**MIKE CAUSEY**  
INSURANCE COMMISSIONER & STATE FIRE MARSHAL

April 4, 2023

**RE: The Springs of Ballentine  
Hectors Creek, NC – Harnett County**

Updated construction documents received on 3-24-2023 relative to the above-named project have been reviewed for a schematic design in general compliance with the 2018 edition of the North Carolina State Building Code with the following comments. This review does not replace the plan review of the local Authority Having Jurisdiction (AHJ). This review is in addition to the plan review of the local AHJ. This plan review may contain comments related to Accessibility, Plumbing, Mechanical, Electrical, and Fire Codes.

C-6

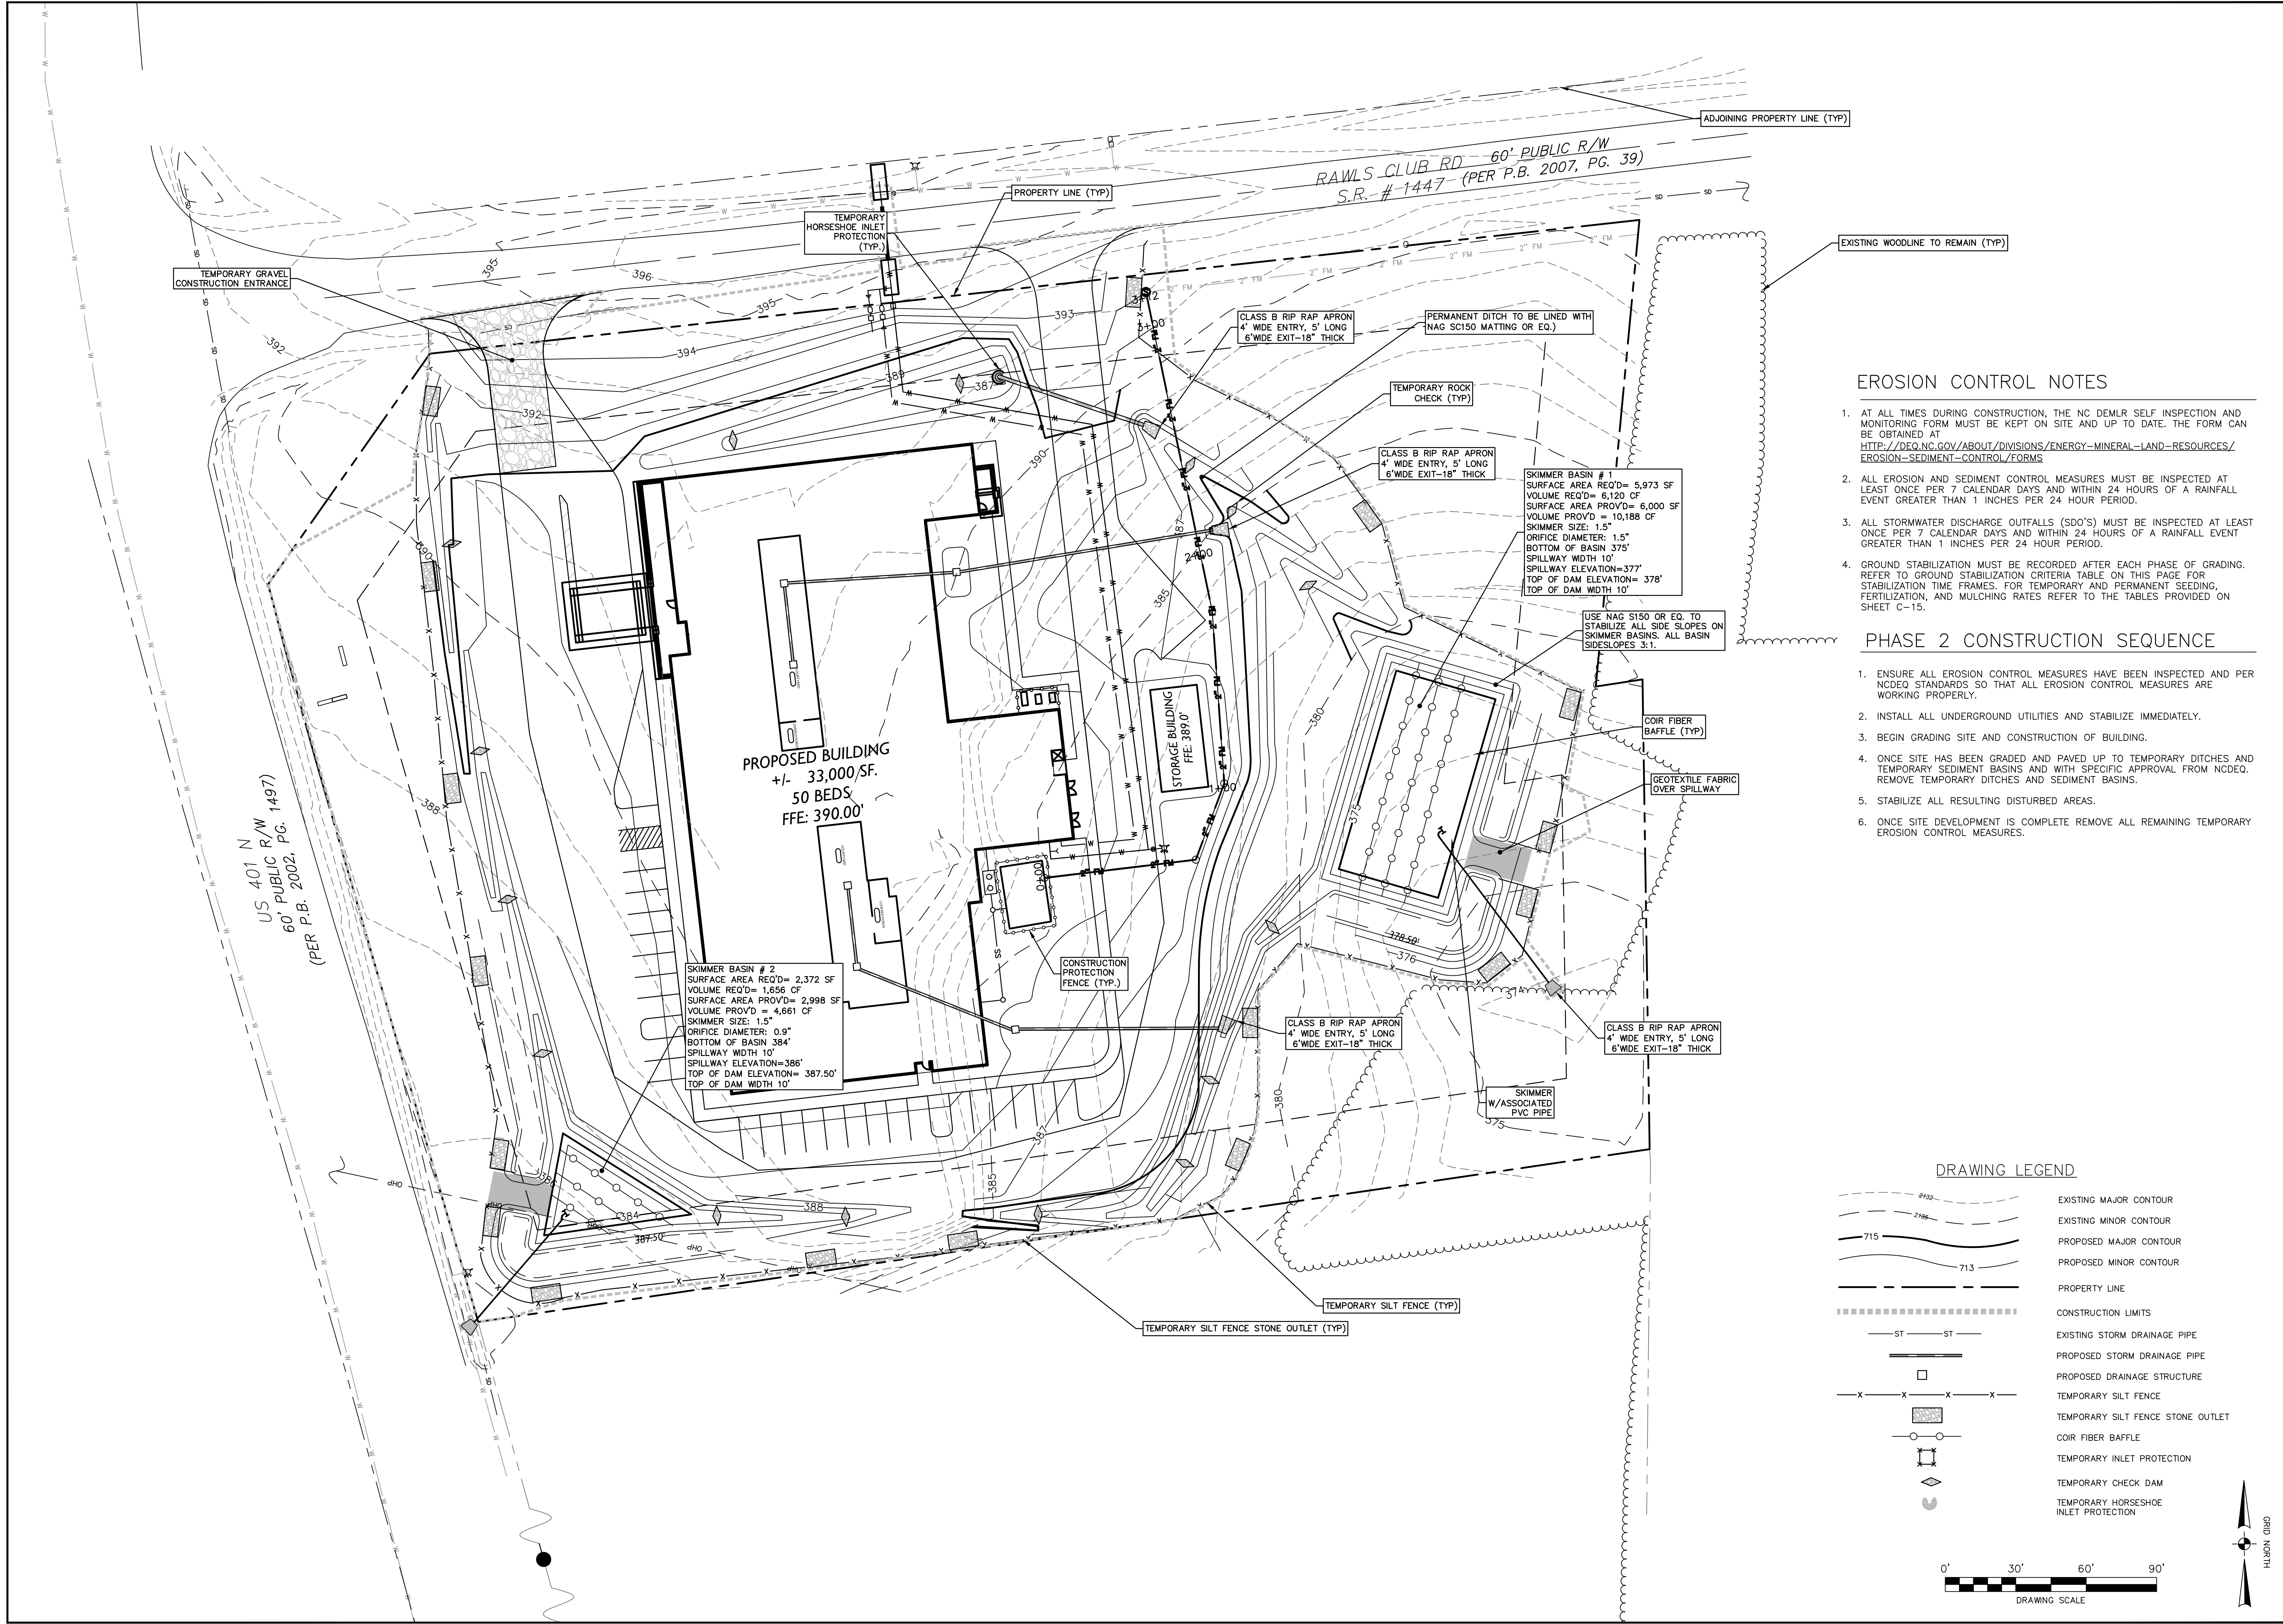
- Building Code, Section 1106.5. This shall be located on the shortest accessible route of travel from accessible parking to the accessible entrance. Impacts pages C-3, C-6 – C-9.
